**Consultation Response from KC,  
Trees**

**2023/92966 Land to the rear of, 271, Cliffe Lane, Gomersal, Cleckheaton, BD19 4SB**

**Demolition of existing dwelling and erection of 87 dwellings including formation of a new access from Cliffe Lane, landscaping, public open space and all associated infrastructure and engineering works**

**Date Responded: 22/11/2023**

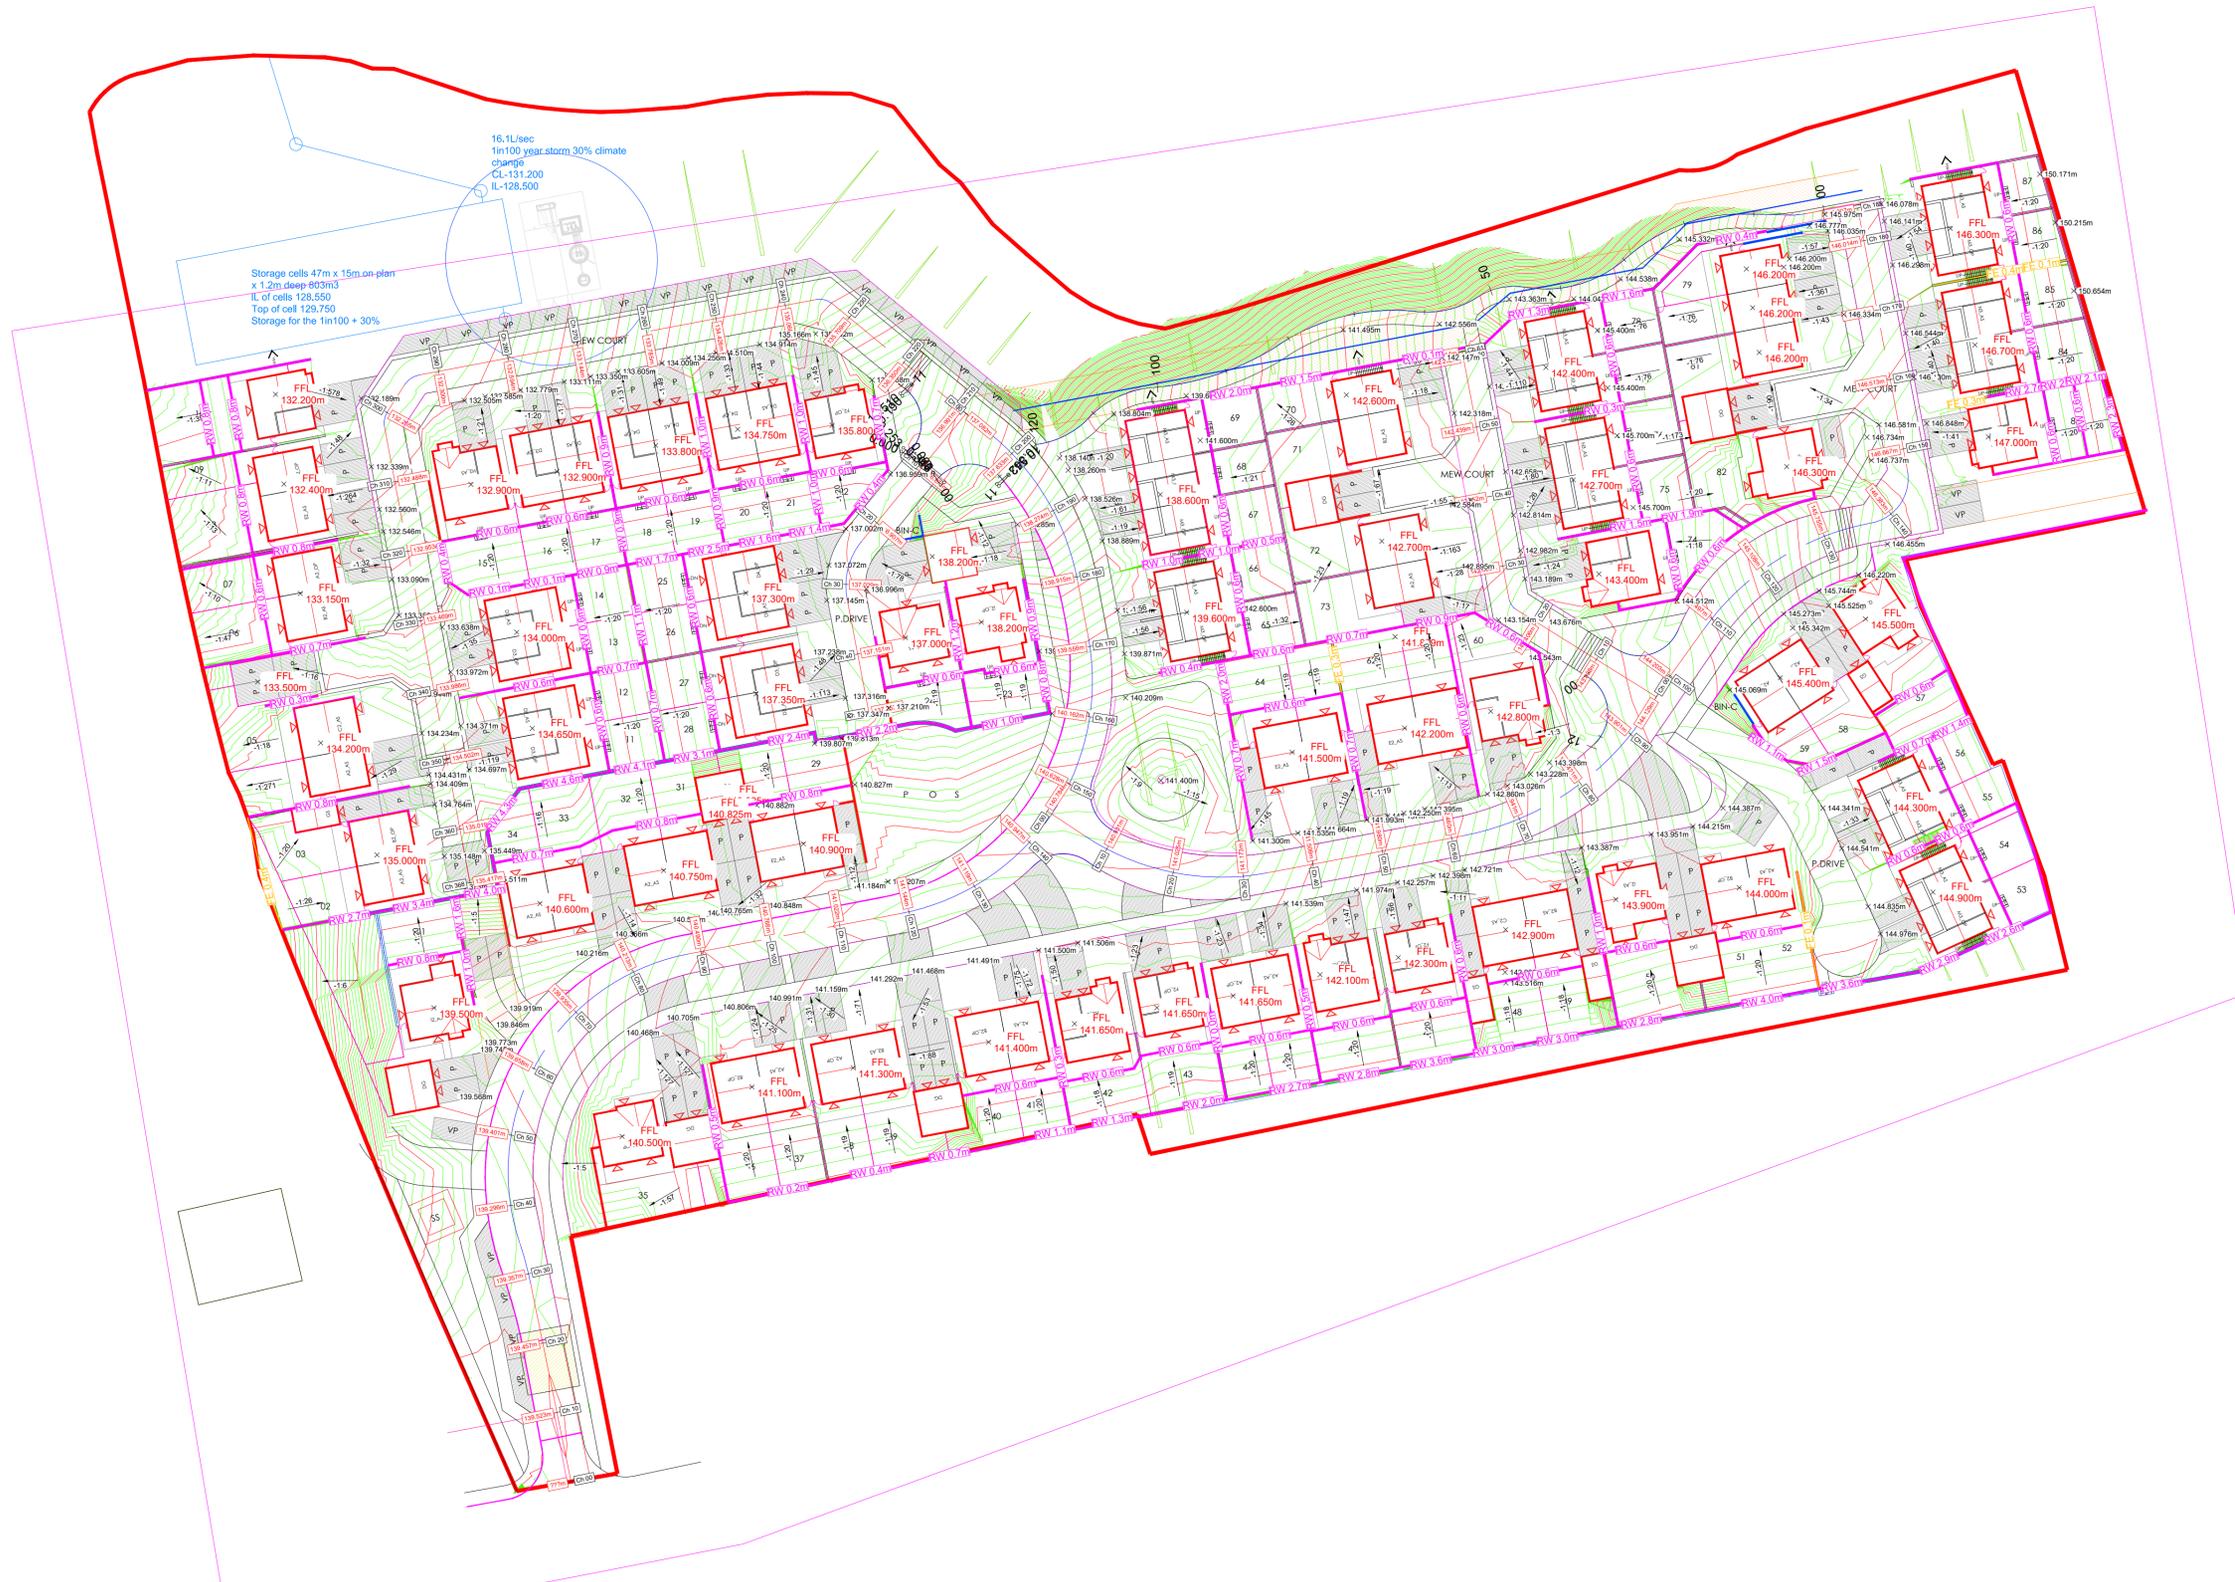
However, T34's RPA appears to be encroached upon as a result of ground level change. The Arb Impact Assessment (AIA) (ARB/CP/307) comments that the encroachment is around the edge and minor. However, drawing 0603-5 P4 and 0603-3 P4 shows contouring right up to the stem of the tree, sloping down from it.

Please can we have clarification on what is being shown and proposed?

For a high amenity tree that is/going to be a focal point within the site. Ideally the RPA should be treated as sacrosanct and structures to address levels be kept outside the RPA.
